1189-1191 CONGRESS STREET

Subject: Application for building permit to allow
construction of one story frame rear addition to
grocery store at 1189 Congress Street.

Subject: Application for building permit to allow
construction of one-story frame rear addition
to grocery store at 1189 Congress Street

1189 - Congress St

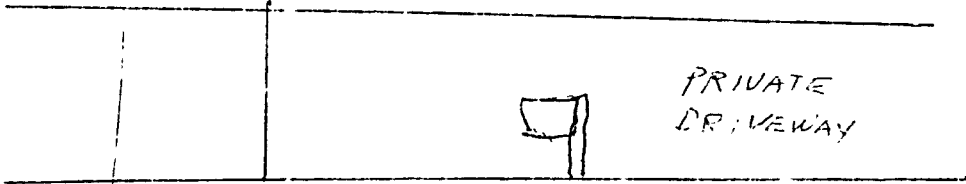
This office is unable to issue a permit to erect a 6' x 14' pole sign (wooden) in the yard of the dwelling at the above address because plans submitted to this office did not tell us how the sign was to be constructed or hung, nor the size of the pole, nor the depth below grade of the pole on which the sign is to be hung.

When this information has been provided to this office by letter or diagram, we will then be in a position to issue the permit.
